Internal Ref: EXTERNAL/2024/0020

Inner West Council Response: SSD-76927247 – The Timberyards by RTL Co.

Property: Lots bound by Victoria Road, Sydenham Road, Farr Street and Mitchell Street, Marrickville NSW 2204

Figure 3. Site proposal within context.

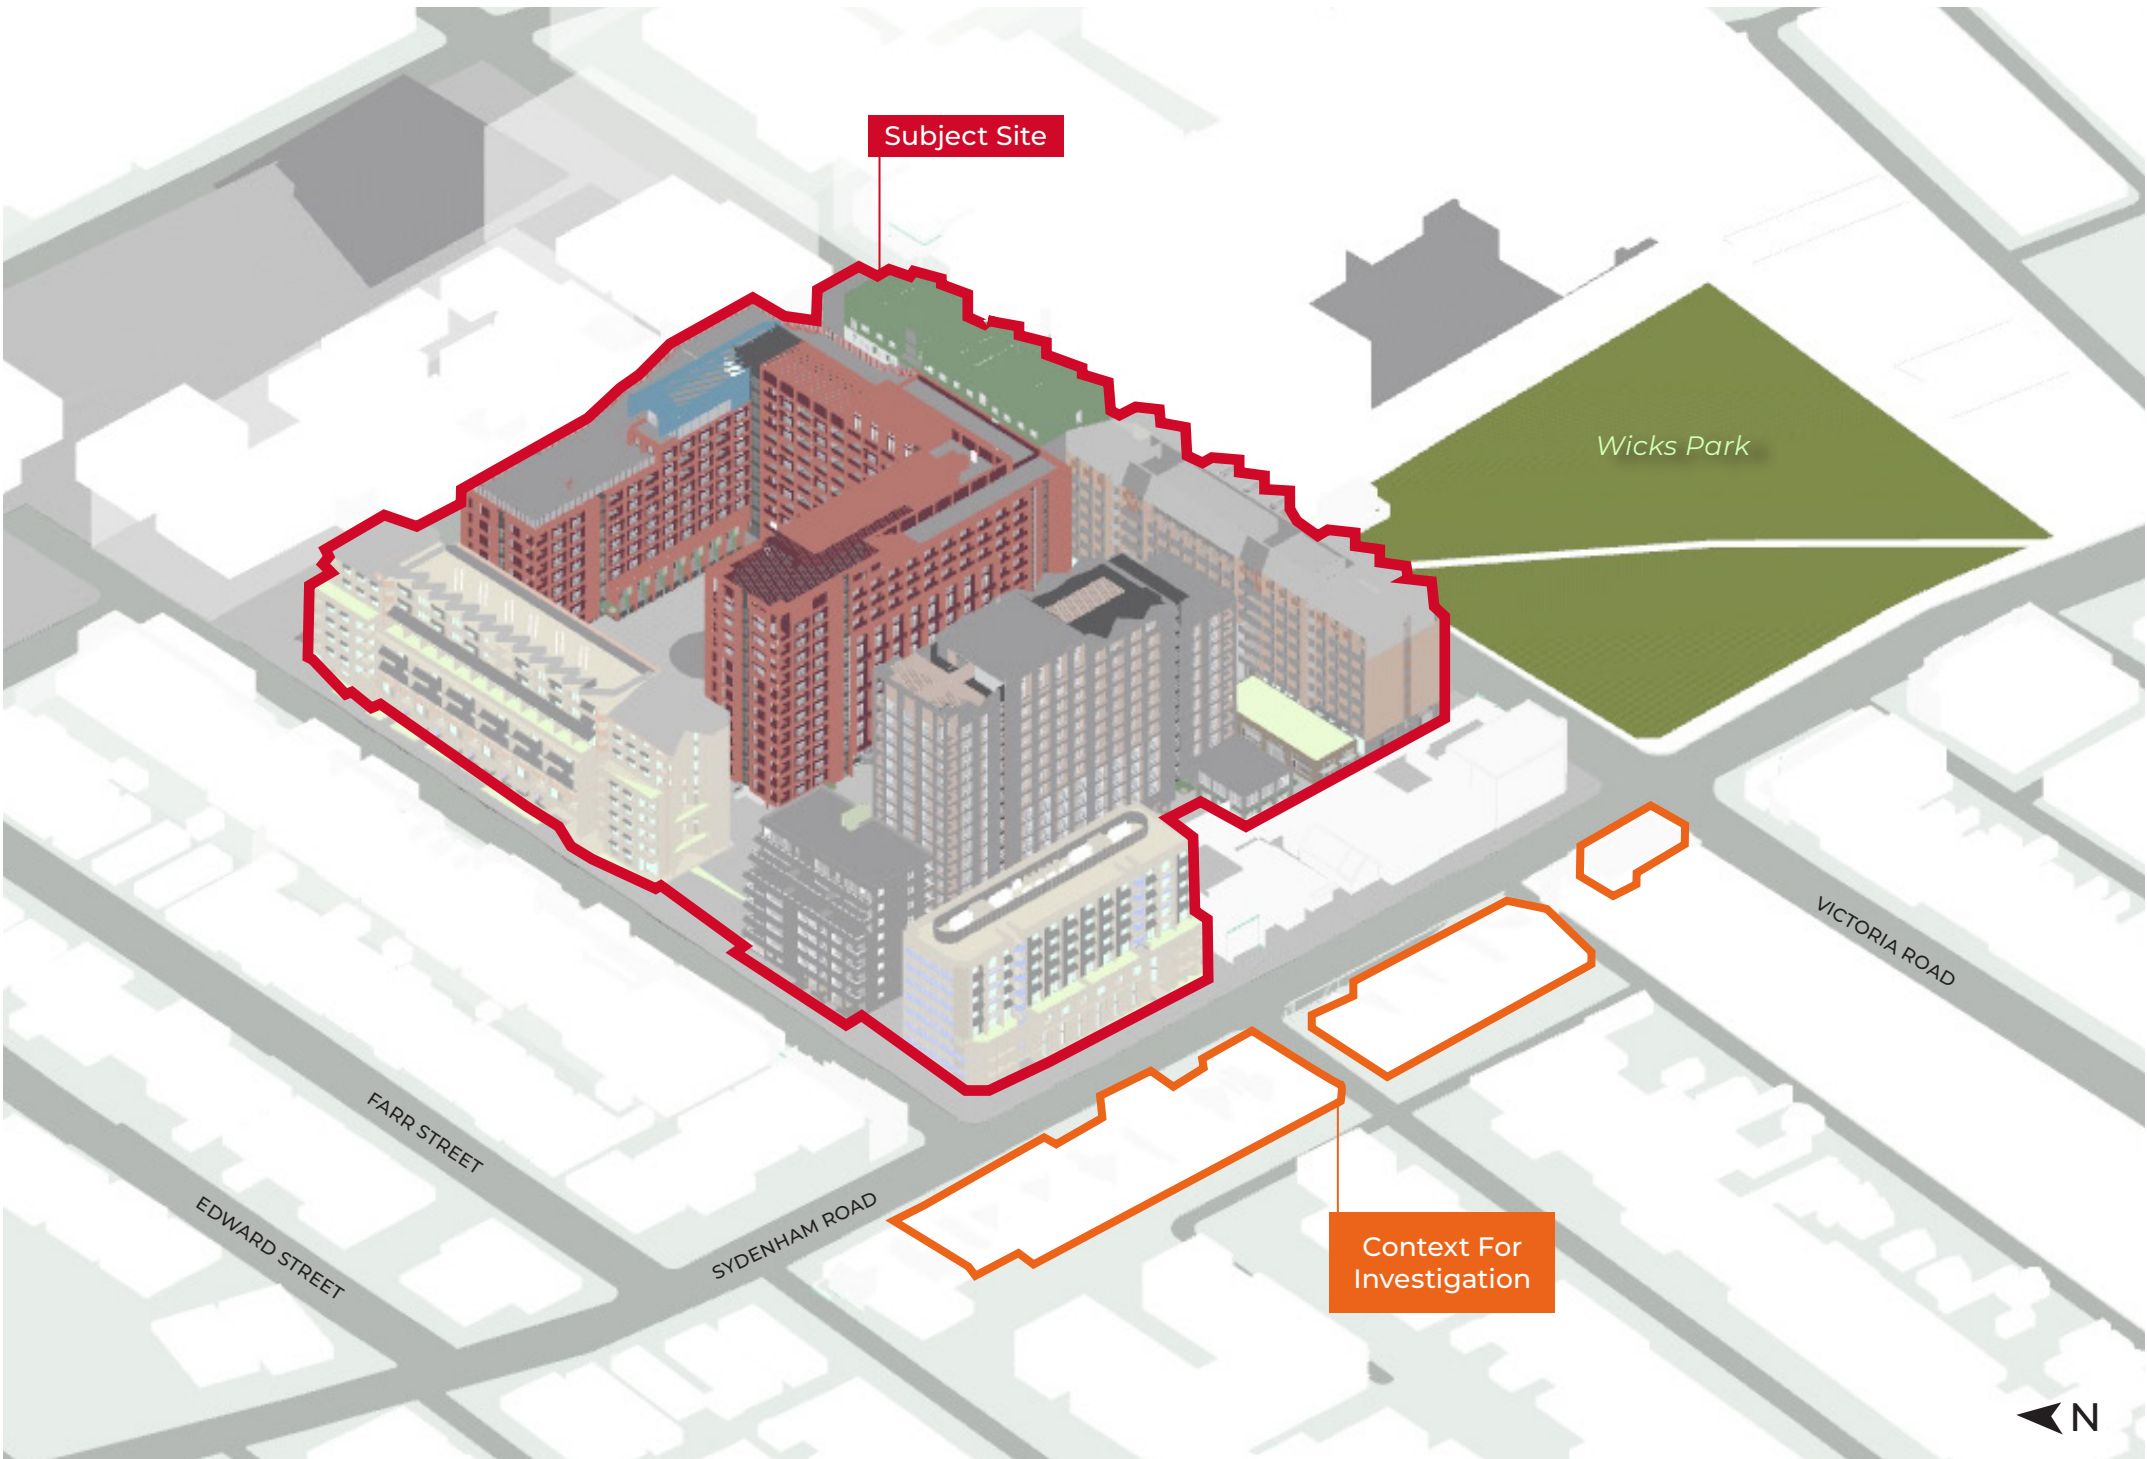
- a) The height of Building G has been reduced by 1 to 3 storeys and the upper-level setback has been increased to 9m from Farr Street. Whilst the reductions are welcomed, Building G still constitutes a 117% (15.5m) variation to the Height of building development standard.

- b) A suitable transition between Building G and the surrounding properties has not been provided. In particular, the revised 8-storey building will not provide an adequate transition to the 'corner site' which has an 11m Height of building development standard under the Inner West Local Environmental Plan 2022 (IWLEP 2022) and a 3-storey height control in Part 9.47 of the Marrickville Development Control Plan 2011. Even when the in-fill affordable housing bonus of *SEPP (Housing) 2021* is used, this would only result in a 4-storey building. The resultant transition from an 8-storey building to a 4-storey building is considered a poor outcome.

- c) The height/massing at the south-east end of Building G compromises the amenity of the existing development and any future development on the 'corner site'. Amenity impacts relate to the visual bulk and scale of Building G and additional overshadowing resulting from the variation in height. This is further discussed with regard to building separation in Part 2a) of this letter.

- d) The proposed gabled roof form adds unnecessary visual bulk, particularly when viewed from the eastern and western (side) elevations.
- e) Notwithstanding the comments raised in 2a) below recommending a greater building separation of Building G and the corner site, the upper levels above the IWLEP 2022 height plane (levels 5-8) identified in blue in Figure 11 below, should have a greater side setback to the south-east side boundary similar to that on the Sydenham Road/Farr Street corner. This would result in a centralised upper portion of the building setback from the north-west (Farr Street), south-west (Sydenham Road) and south-east (adjacent to corner site).

- f) The south-west corner of Building G has an applicable Height of building development standard of 11m. The portion of the building within this area (corner of Sydenham Road and Farr Street) should be reduced in height to provide a more suitable transition to the properties to the south-west. This would constitute a greater setback from Farr Street at level 3.
